Subject: RE: FG/51/20/HH - 66 Elm Park Farm

Proposed Roof Plan

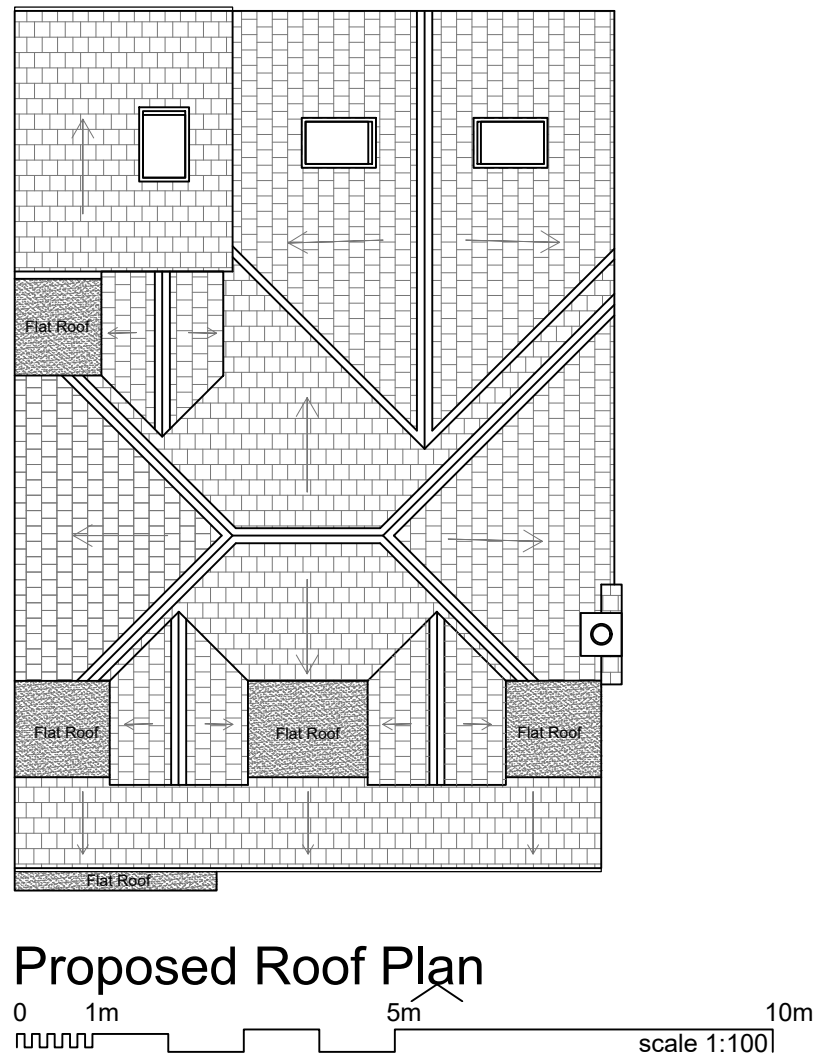
One large area of concern is potential inaccuracies on the plans, I was wondering if you could clarify. The hips of the main roof on the roof plans show these elements going 'through' the flat roof parts of the dormers, whereas on the elevations, this appears different as they appear to line up. I was wondering if you are able to clarify this?

I believe I have adjusted these now, you were quite right in terms of the inaccuracies.
